Project Title: Netherwood Commons

DRAINAGE REPORT
for
NETHERWOOD COMMONS

RE: GRADING & DRAINAGE PLAN FOR NETHERWOOD COMMONS (H-17/D84)
RECEIVED JULY 22, 1996 FOR BUILDING PERMIT
ENGINEER'S STAMP DATED 7/19/96

RE: DRAINAGE REPORT FOR NETHERWOOD COMMONS (H-17/D84)
RECEIVED JUNE 21, 1996 FOR BUILDING PERMIT
ENGINEER'S STAMP DATED 6/19/96

NETHERWOOD COMMONS
GRADING & DRAINAGE PLAN

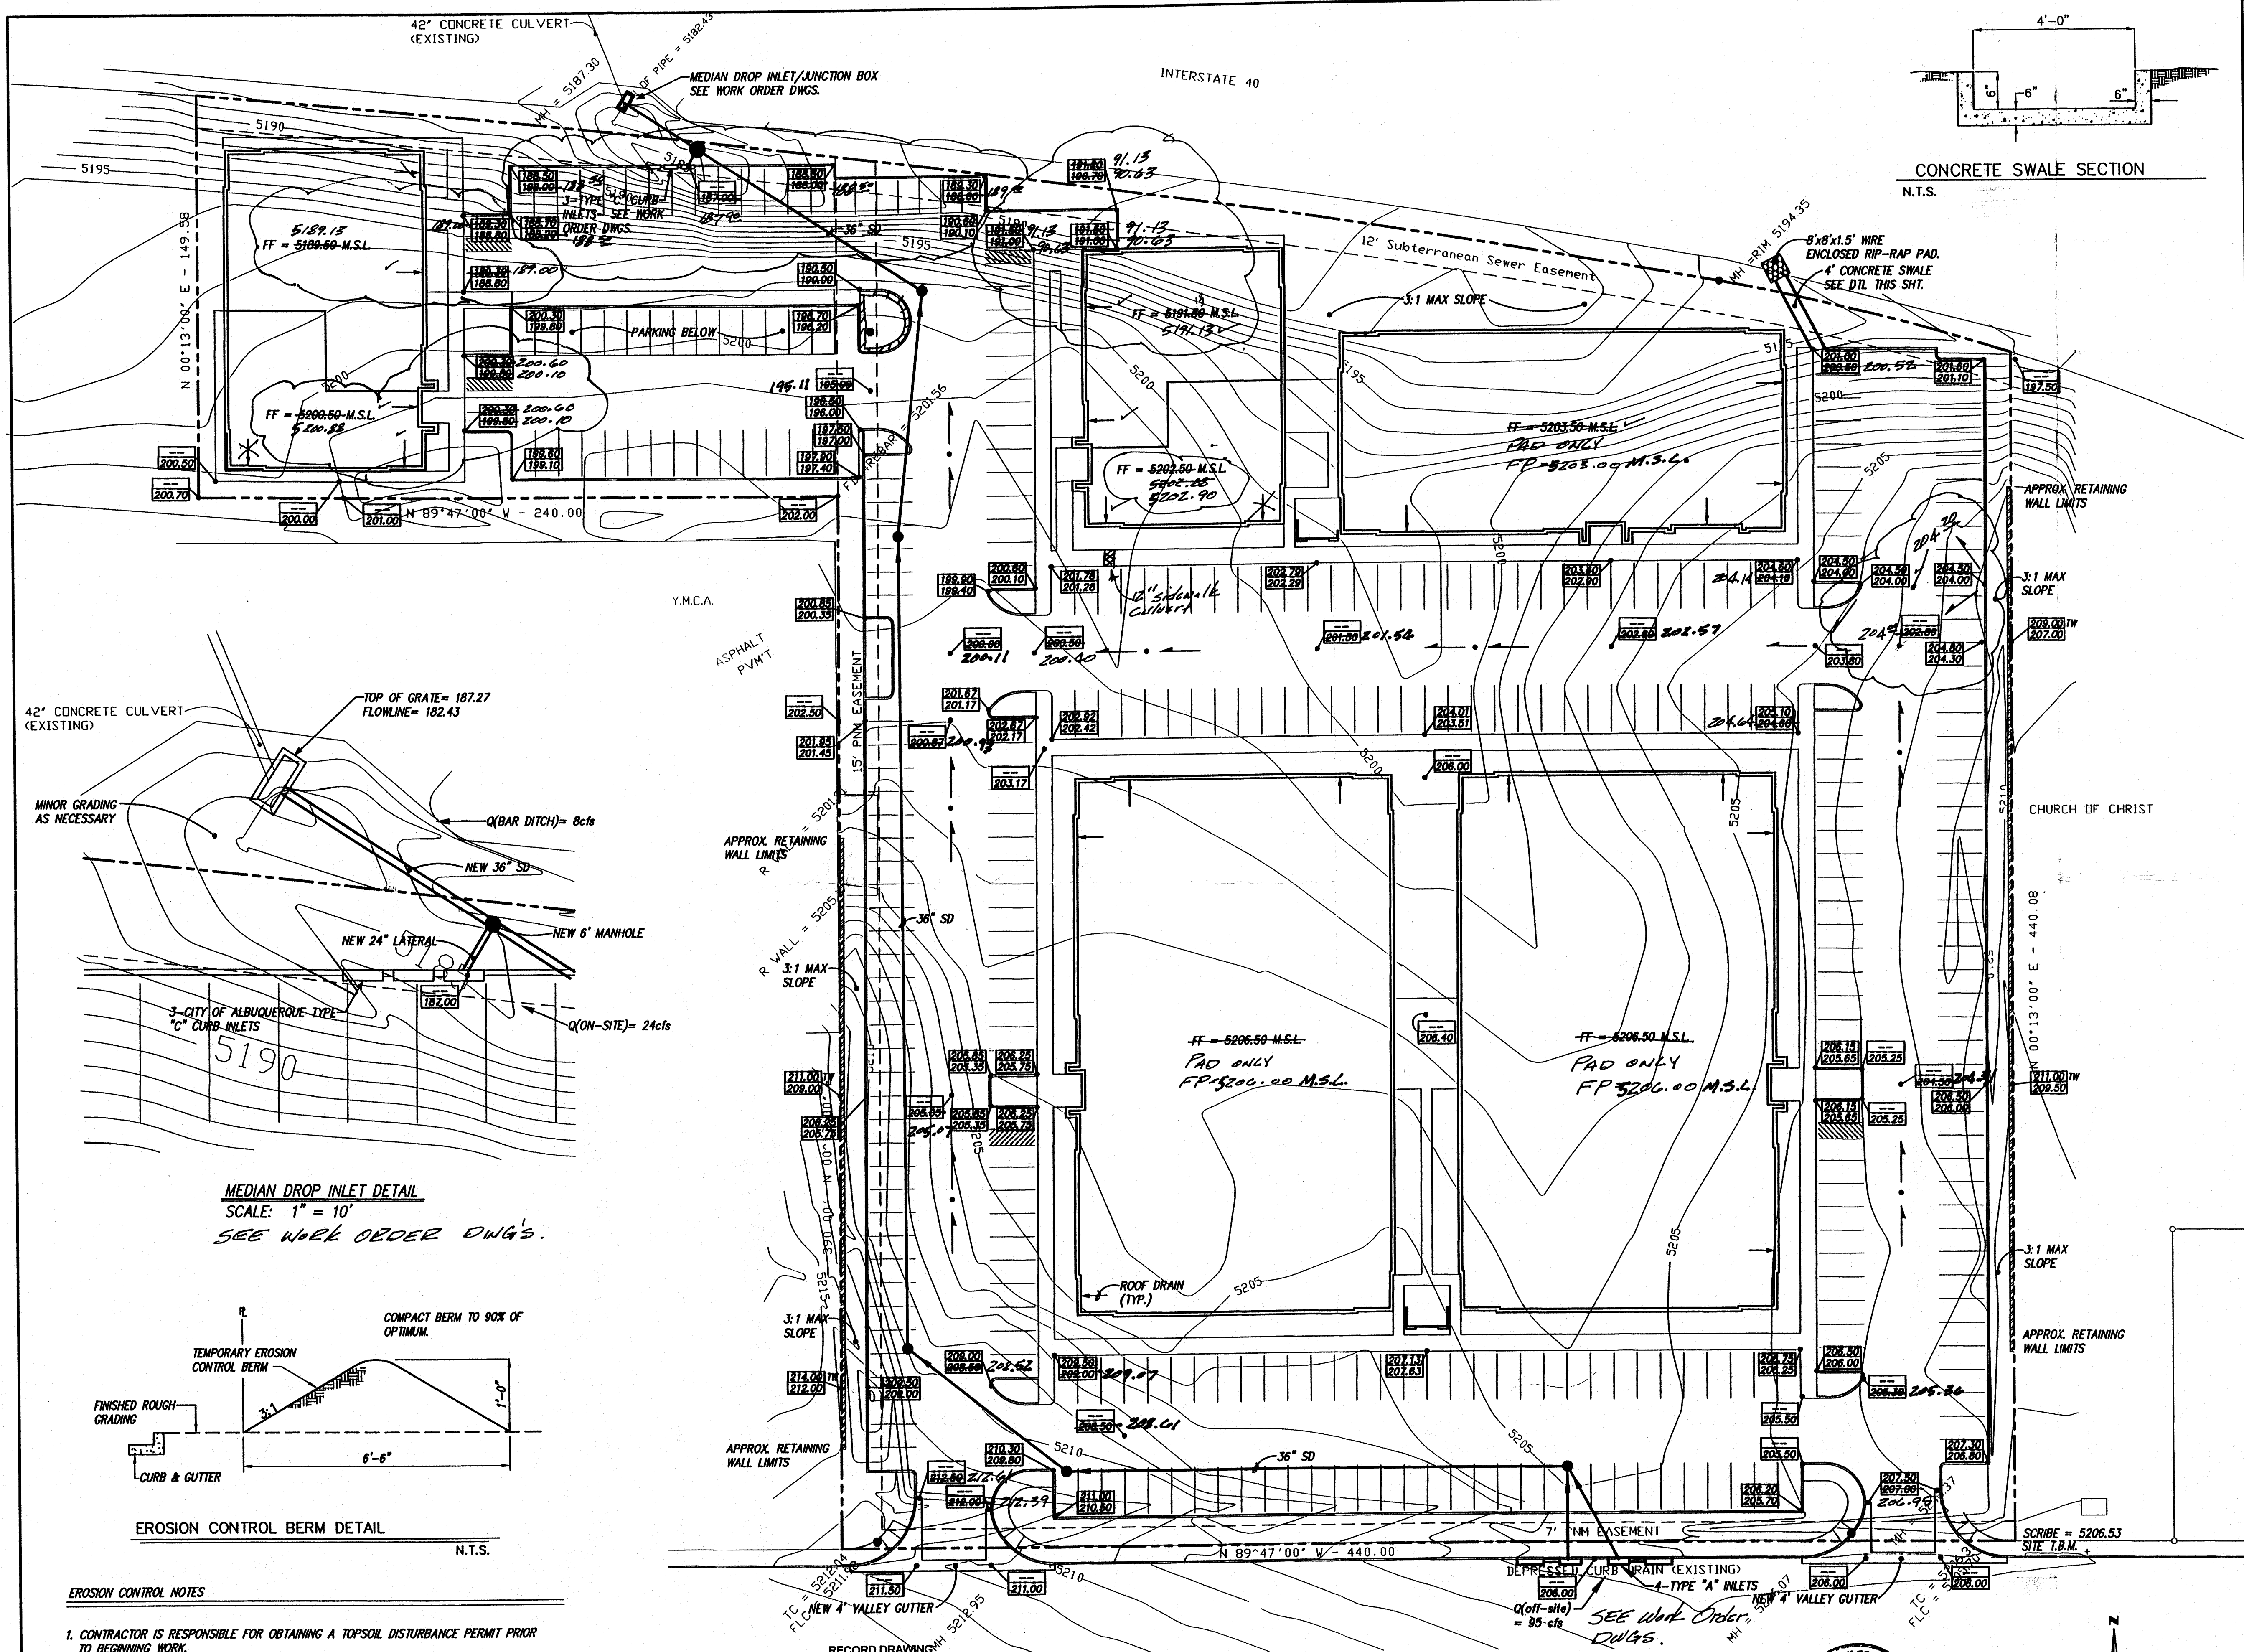
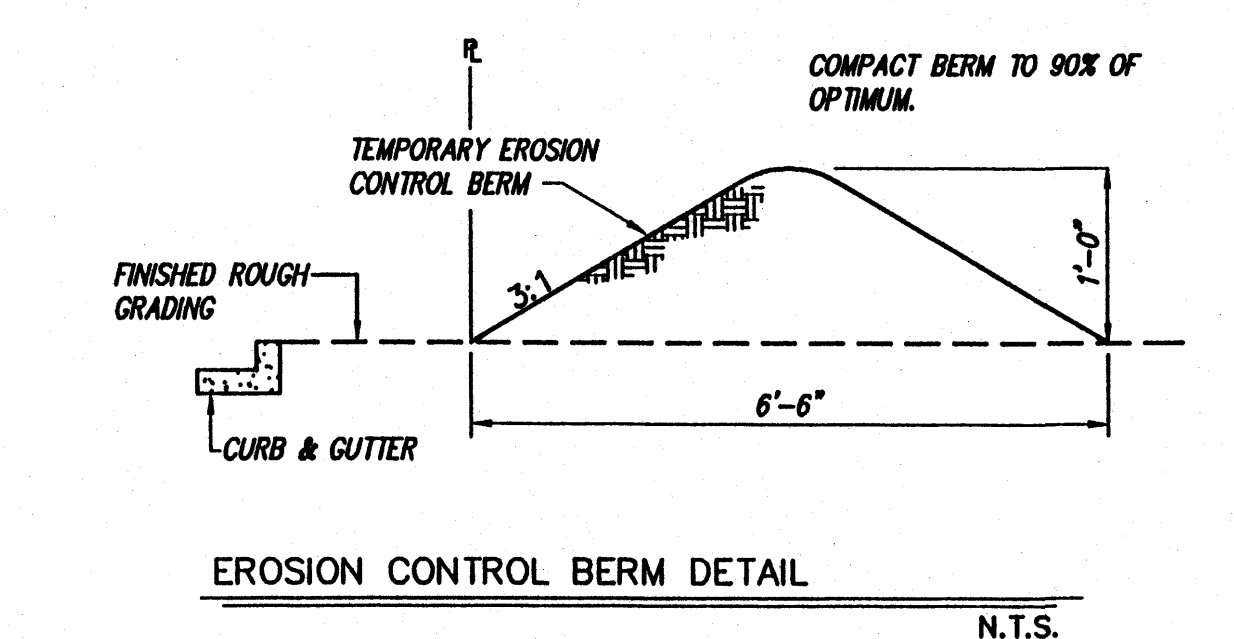
For Building Permit: Include an erosion control plan and the concrete swale detail on the Grading & Drainage Plan. A "topsoil disturbance permit" must be obtained prior to construction.

For Work Order: Submit final design calculations for the storm drain. Indian School is a minor arterial. Check 10 year criteria. Consider using Type "A" inlets with double grates & wings on both sides at sump or sag conditions. Storm drain will require a drainage easement. Obtain a permit from NMSHTD for work in their right of way.

NETHERWOOD COMMONS
GRADING & DRAINAGE PLAN

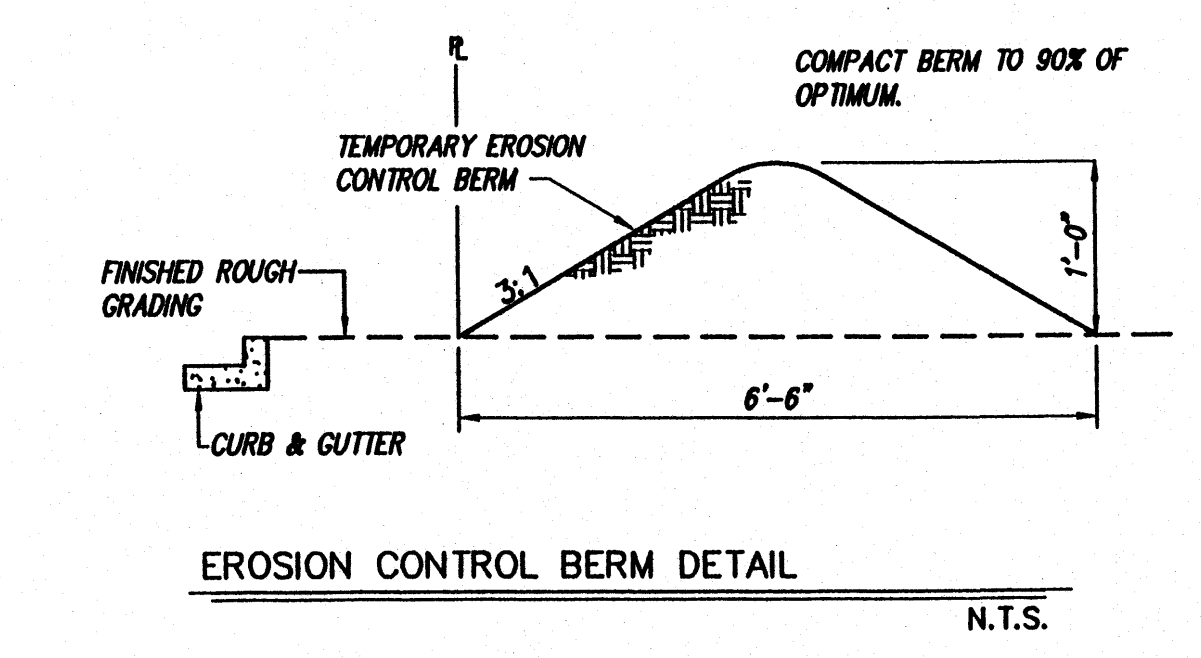
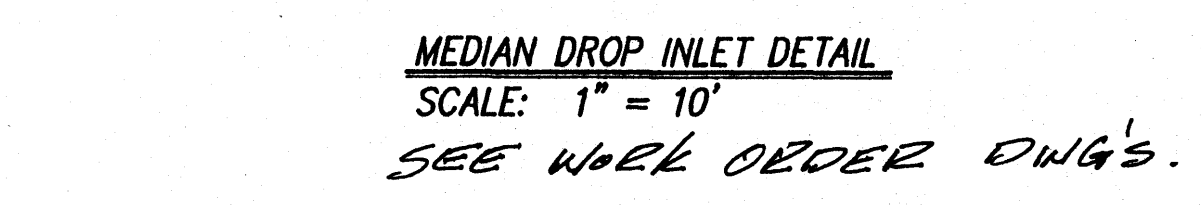
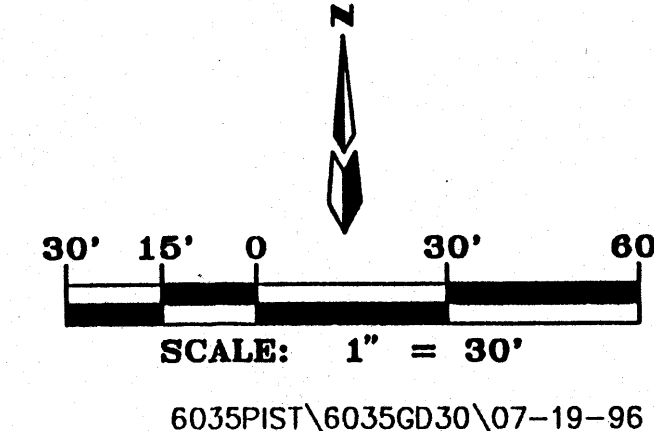
1. Pad elevations must be shown to full mean sea level designation.
2. Concurrence from the Highway Department for work done within their R/W.
3. Copy of the letter of acceptance for the work order items.
4. More as-built spot elevation within the parking areas.
